From: Masha White [REDACTED]
Sent: 29 January 2026 13:03
To: Planning <Planning@arun.gov.uk>
Subject: Objection to FP/167/25/HH

Application No. FP/167/25/HH 7 Lindsey Court, Felpham

Proposed Annex
Plans and Elevations
Planning
Date
March 2022
Scale
1:50

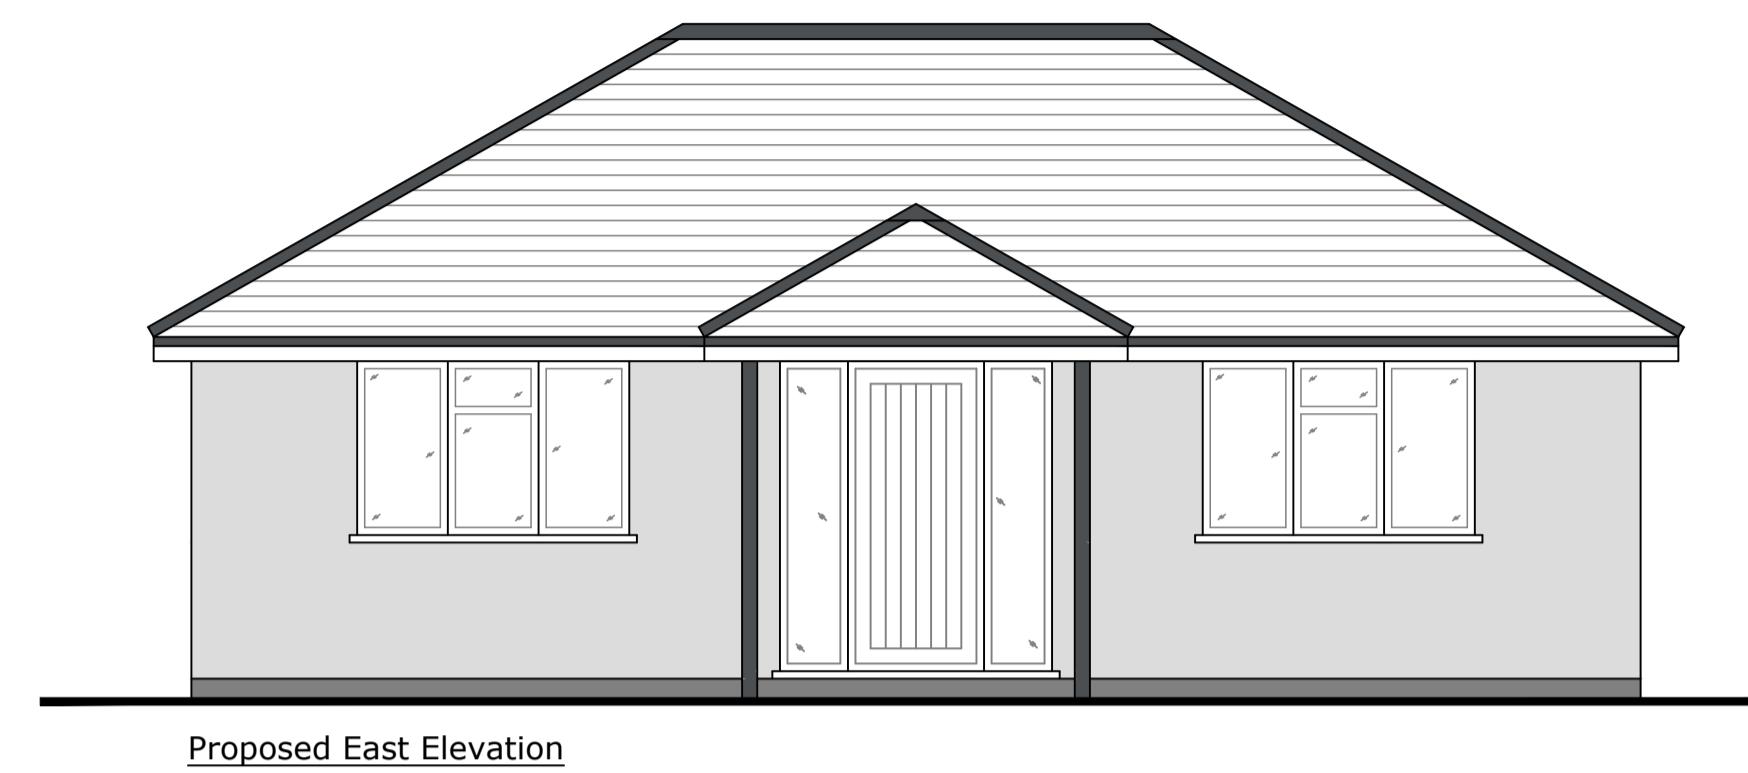
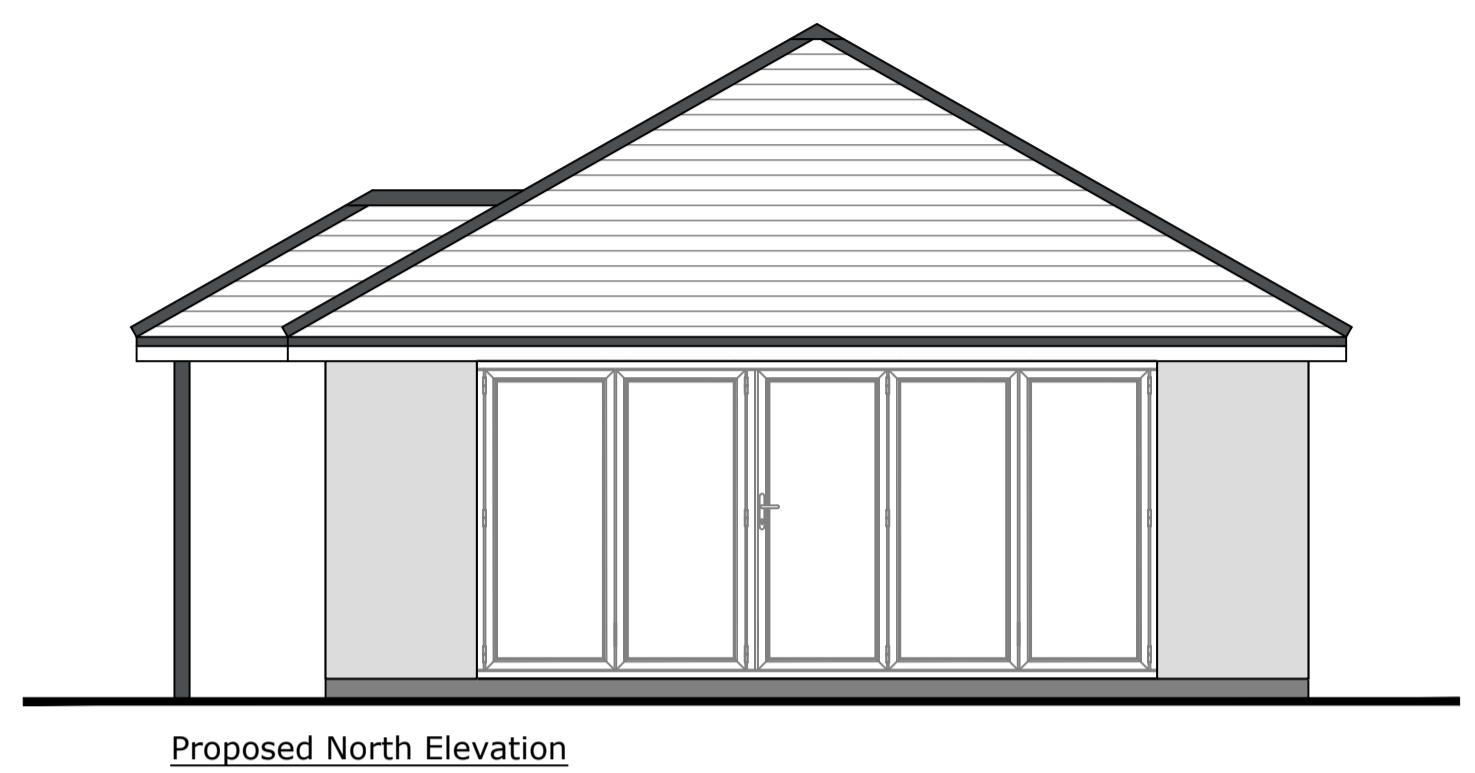
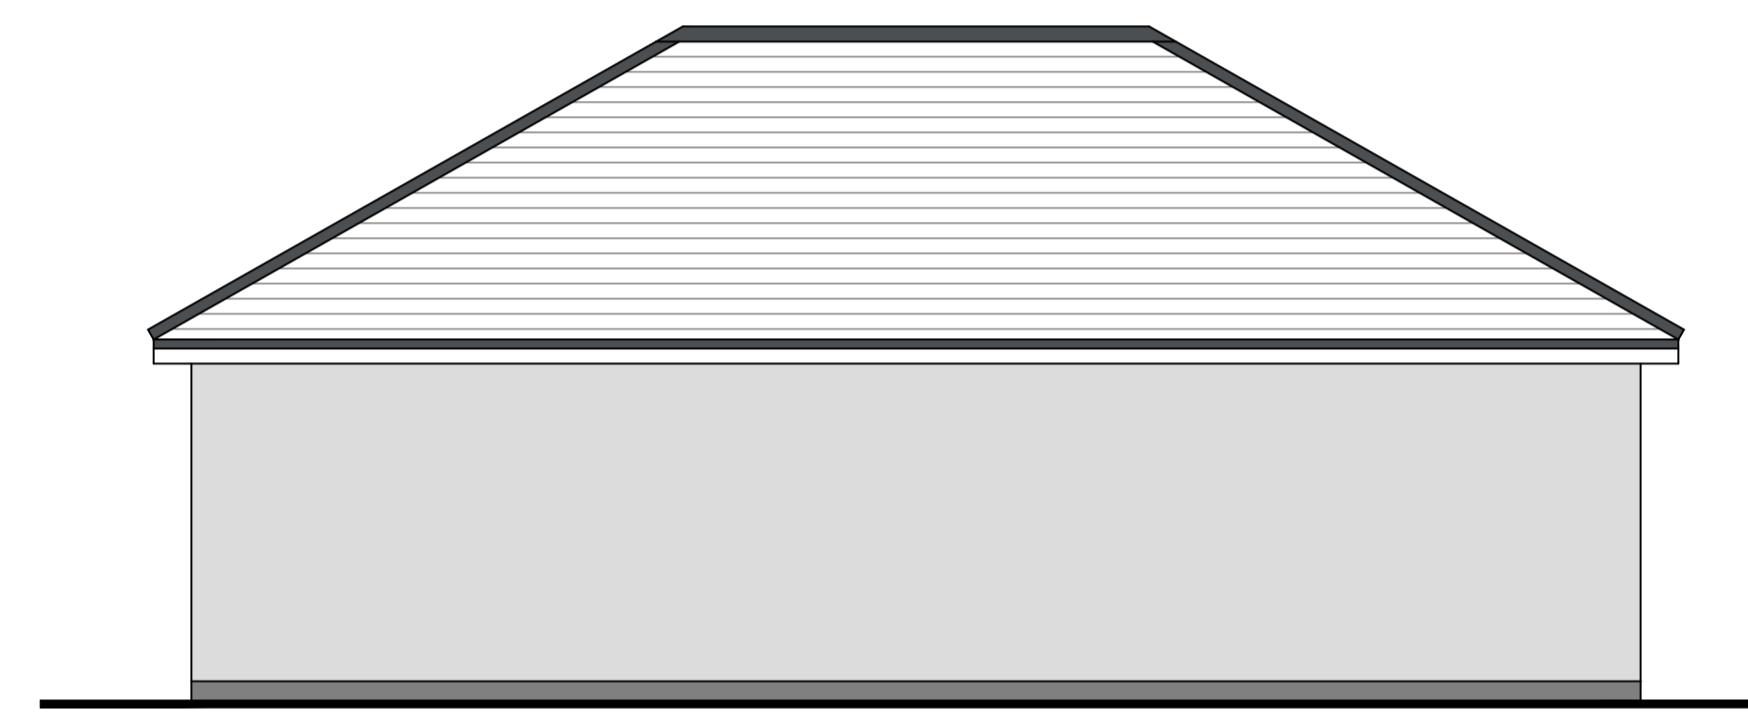
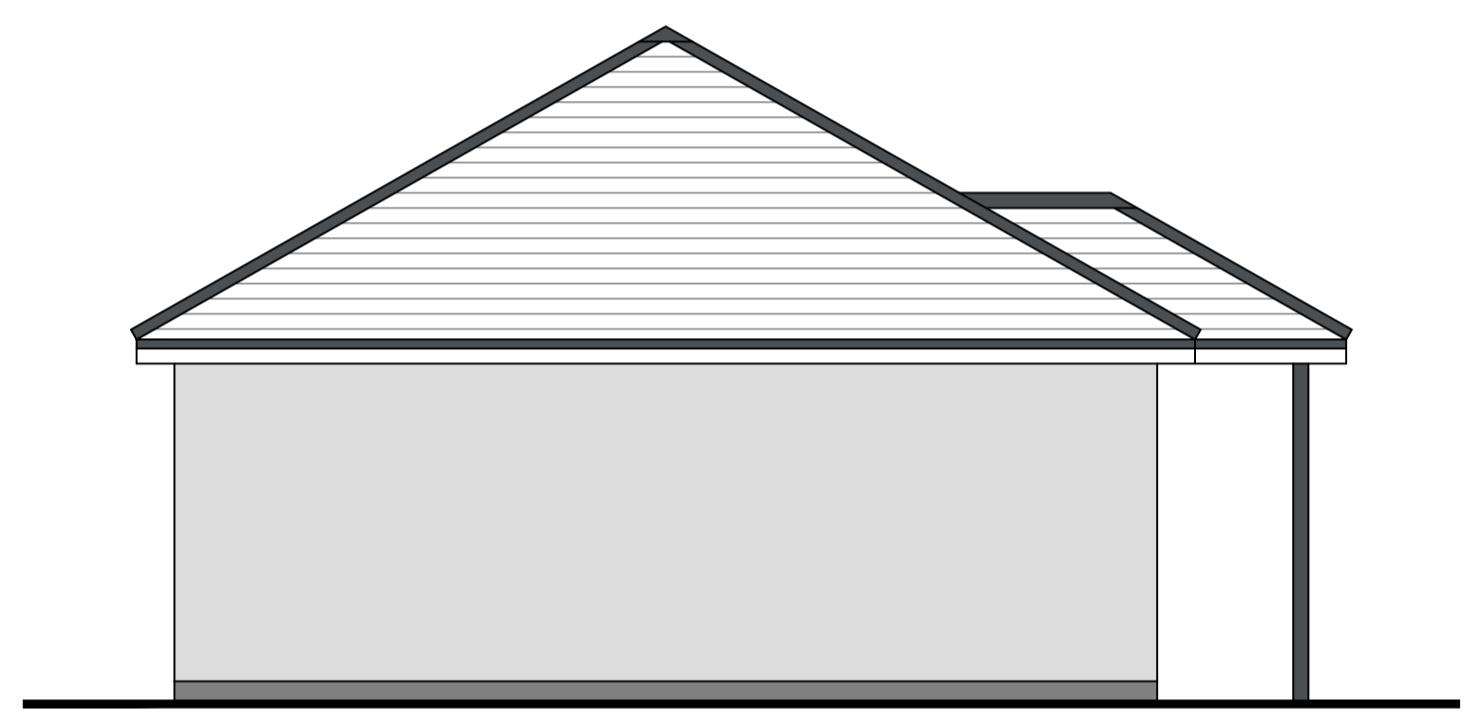
2. We are particularly concerned that the proposed building would be right on our boundary. There is no provision for access to the rear or side of the property for regular maintenance. Under the terms of the 1990 Town and Country planning Act, for buildings up to 2.5 meters in height a space of 0.3 to 1.0 meters is usually considered practical and if the building is within 2 meters of a boundary its maximum height must not exceed 2.5 meters. If the building is taller, up to 4 meters it must be positioned at least 2 meters from the boundary. The plan submitted does not specify dimensions, but given the fact that it would have a pitched roof we believe it would be more than 4 meters high.

4. Siting the new build against our boundary means that given the pitched roof our garden would collect fall out from the trees in the form of the regular acorn and leaf dropping. We already have a huge amount of such deposits and do not want more from next door. Every few years (Mast Years) Oak trees are subject to exceptional falls of acorns. Autumn 2025 was such a year. We had to collect and remove over 300 kilos of Acorns from our garden and the applicant had at least a similar amount, it therefore seems unreasonable that we should collect even more via the roof of the new build.

7. We were informed after the previous application that a special technique could be used to protect the tree roots to build on a type of raft with a crawl space under the building. Such a system if utilised would of course further increase the height of the building by 0.5 to 1.0 meters.

Proposed Ground Floor Plan

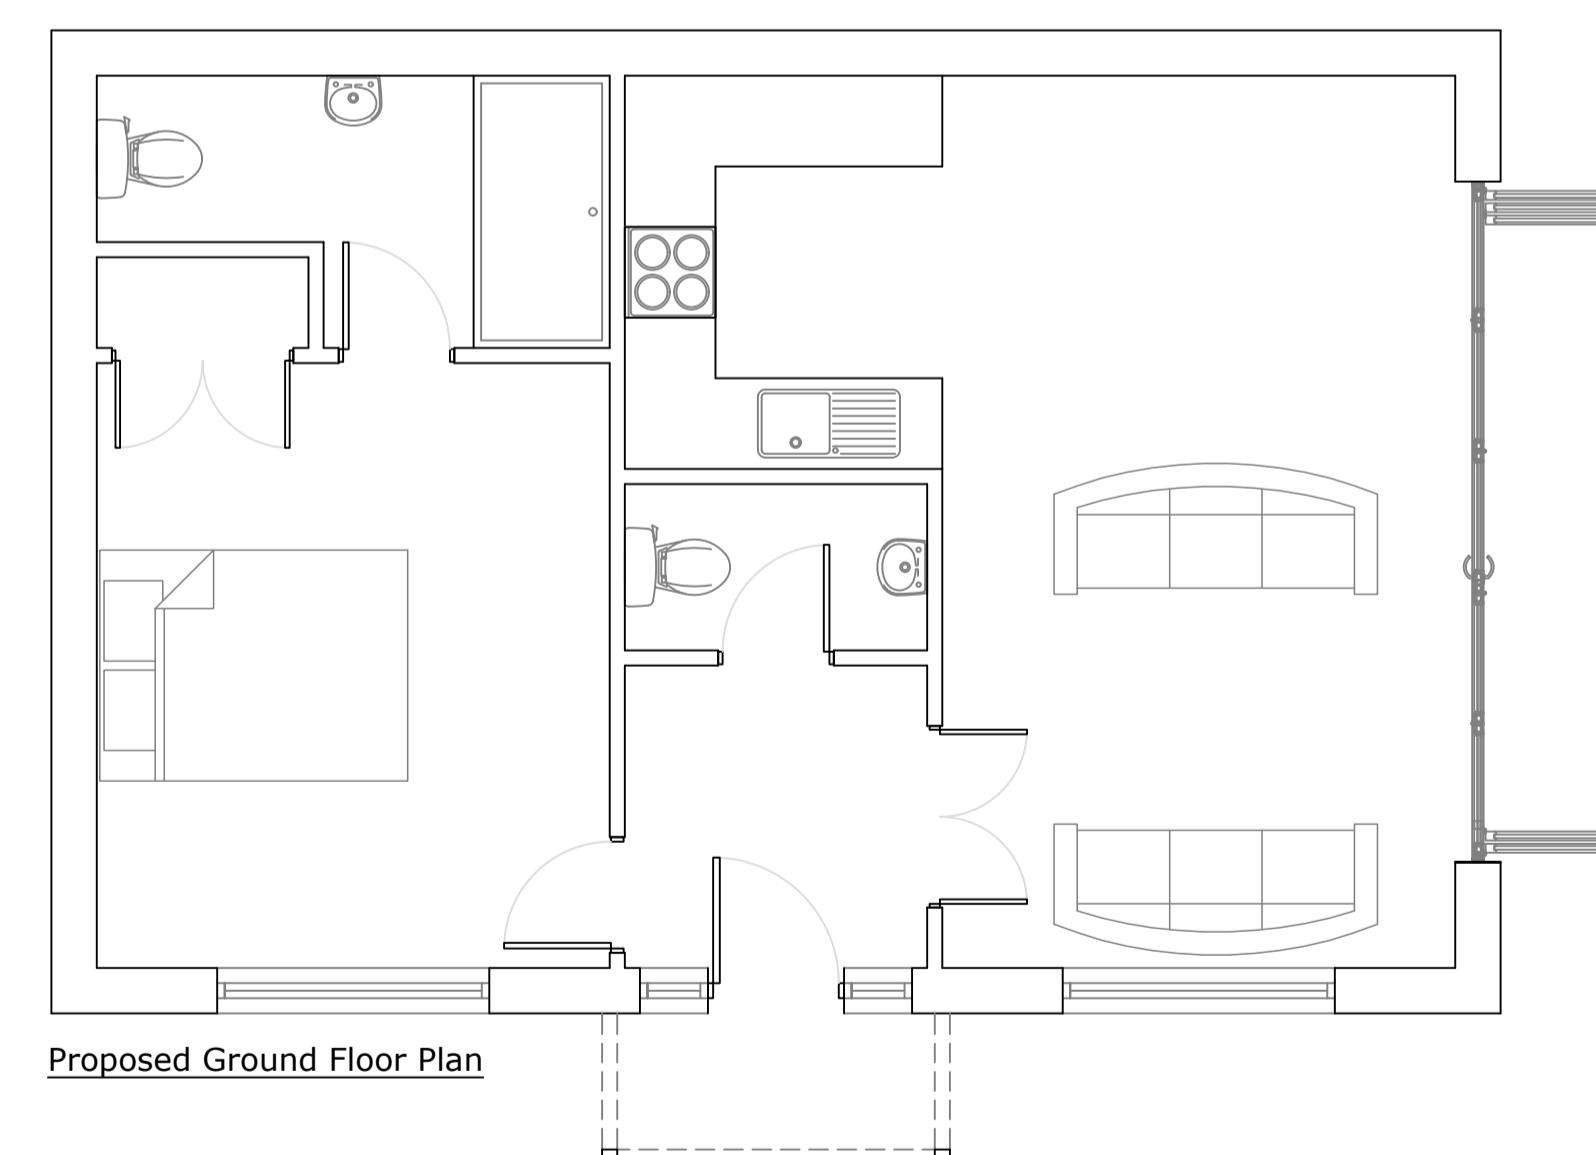
3. When “Site 6” was being developed to the rear of our garden we were told that no new building could take place within 25 meters of established TPO trees. The new build is well within 25 meters of our TPO tree and those in the applicant’s garden. The canopy from these mature Oak trees would overhang the new build.
